From: [Jordan Bovee](#)
To: [Zach Torrance-Smith](#)
Subject: Re: SPF-25-00009 Mills - Request for Final Short Plat Review
Date: Tuesday, December 9, 2025 2:34:29 PM

TO: All Staff
FROM: Public Works Plan Review Team
DATE: December 15, 2025
SUBJECT: SPF-25-00009 Mills

DRAWN BY CJG/MBG	MILLS-2 SHORT PLAT FOR: <b>MARK AND AMY MILLS</b>		JOB NO. 1223
CHECKED BY MBG	4640 W. DRY CREEK ROAD	ELLENSBURG, WA 98926	DATE 11/24/25
MBG Surveying P.O. Box 262 Coviche, Washington 98923 (509) 949-5797			SHEET 1
			OF 2

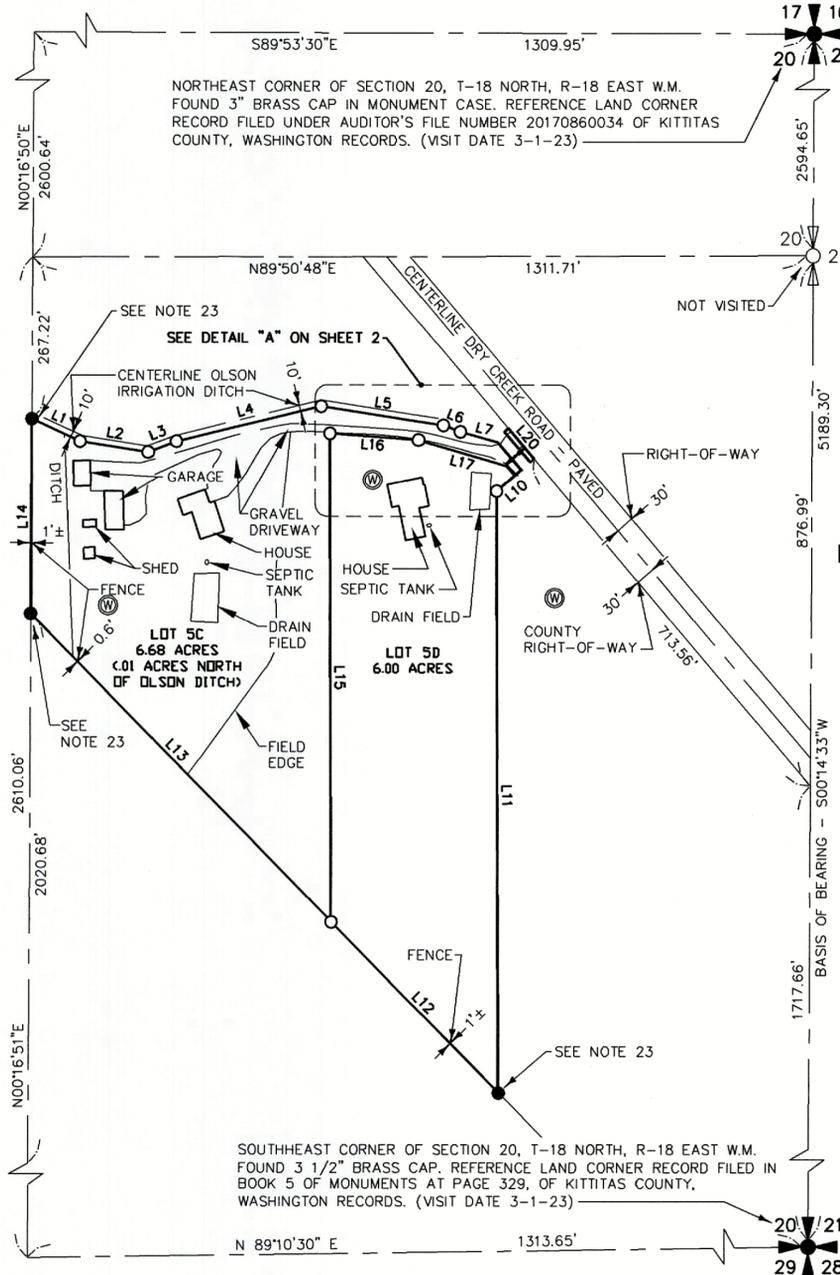
SURVEY	Legend needs to be added. (DF)
TRANSPORTATION CONCURRENCY	No transportation concurrency requirement for this project.
FLOOD	No comments. (SC)
WATER MITIGATION/ METERING	KCC 13.35.027 requirements for water mitigation and metering have been met for final plat approval. (SC)
AIRPORT	No Comments. (RC)
